**From:** Nicola Oktay on behalf of Planning.Responses  
**Sent:** 10 April 2025 11:43  
**To:** Planning Scanning  
**Subject:** FW: FG/32/25/HH

**From:** Andrew Lyons [REDACTED]  
**Sent:** 09 April 2025 20:25  
**To:** Planning <[Planning@arun.gov.uk](mailto:Planning@arun.gov.uk)>  
**Subject:** FG/32/25/HH

I have recently seen the planning application for the proposed fence at 1 Greenways Crescent, Ferring.

DRAWING TITLE
Existing Site Plan

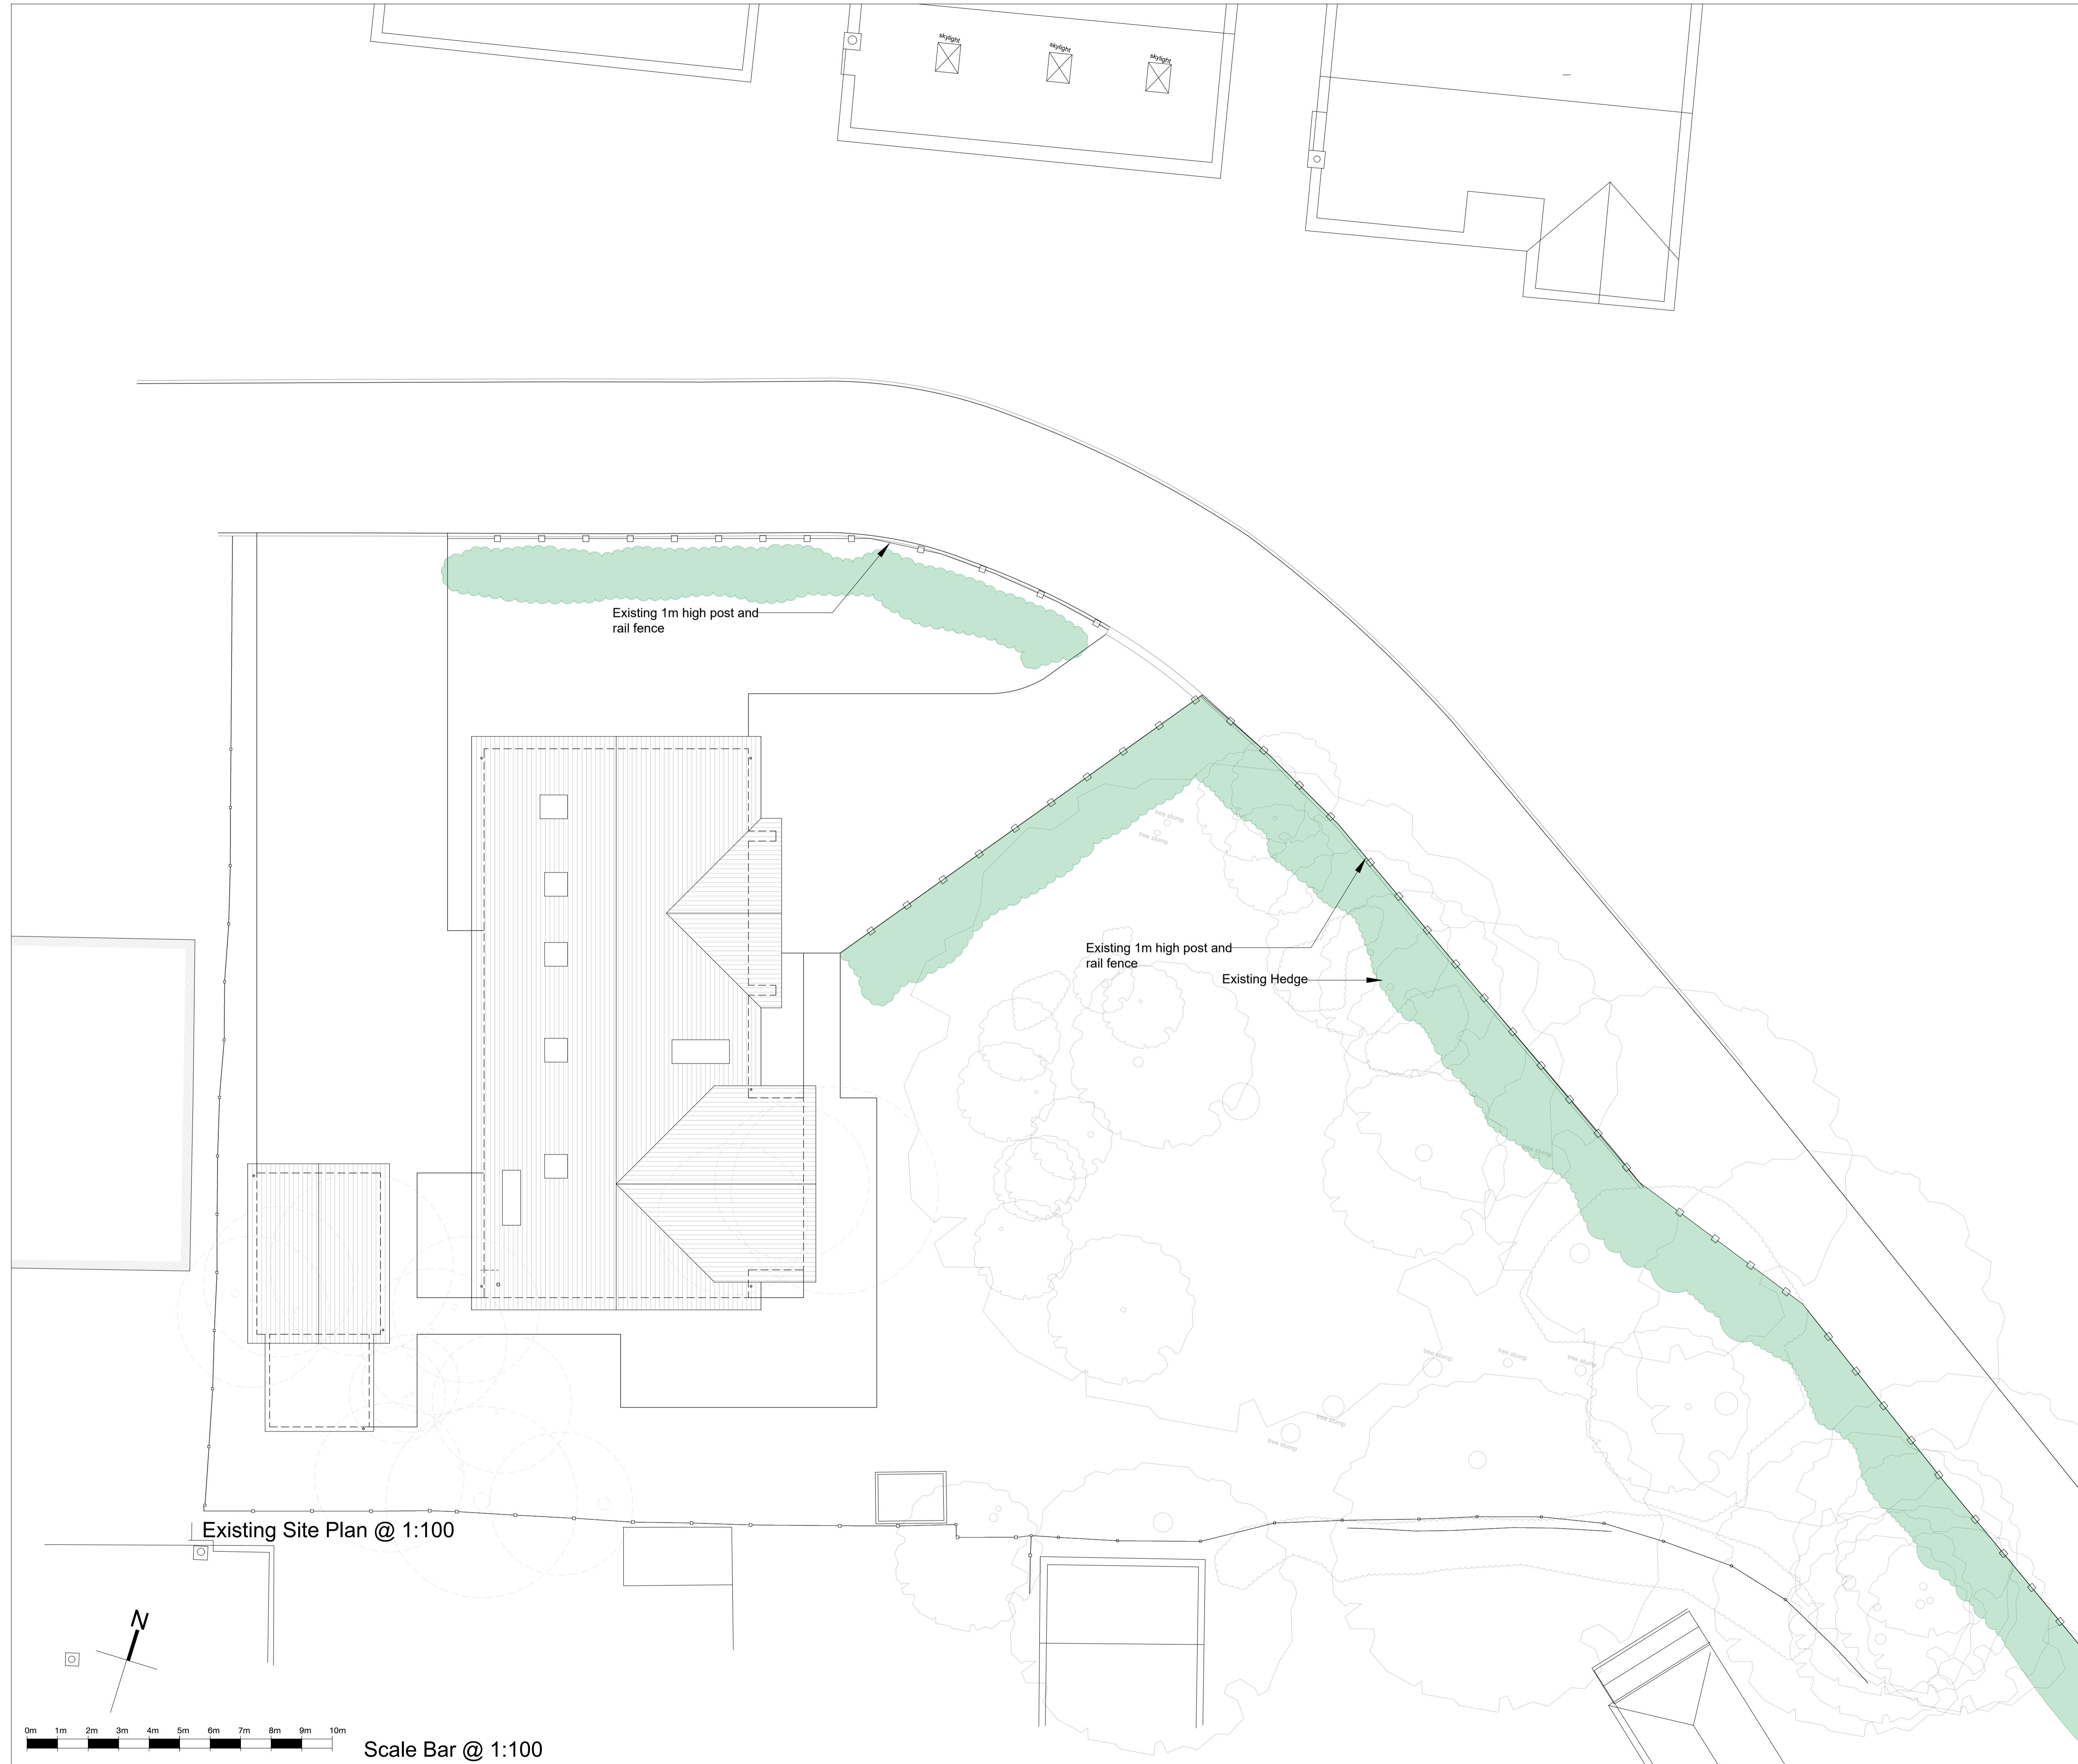
However the plans submitted are very confusing. They appear to show the existing fence moved to the kerbside and the new fence 2 m back from this. Some of the hedge is shown in front of the fence and some is behind. Without any planting in front of the proposals would be very harsh on the street scene. The proposals show the fence extending beyond the boundary of the property and continuing down Greenways Crescent beyond the boundary of the site. The written descriptions on the drawing do not seem to match with the graphical information shown. The plans and elevational drawings seem to show a lot of vegetation that does not exist.

On the basis of the drawings as they stand I will have to object unless the exact proposals are clearly shown. It will make a huge difference to the street scene if the proposed drawings are implemented as shown on the drawings now or at any point in the future. The proposals as shown will place the post and rail fence right on the kerb at the apex of a bend in the road hindering visibility of cars going along the road.
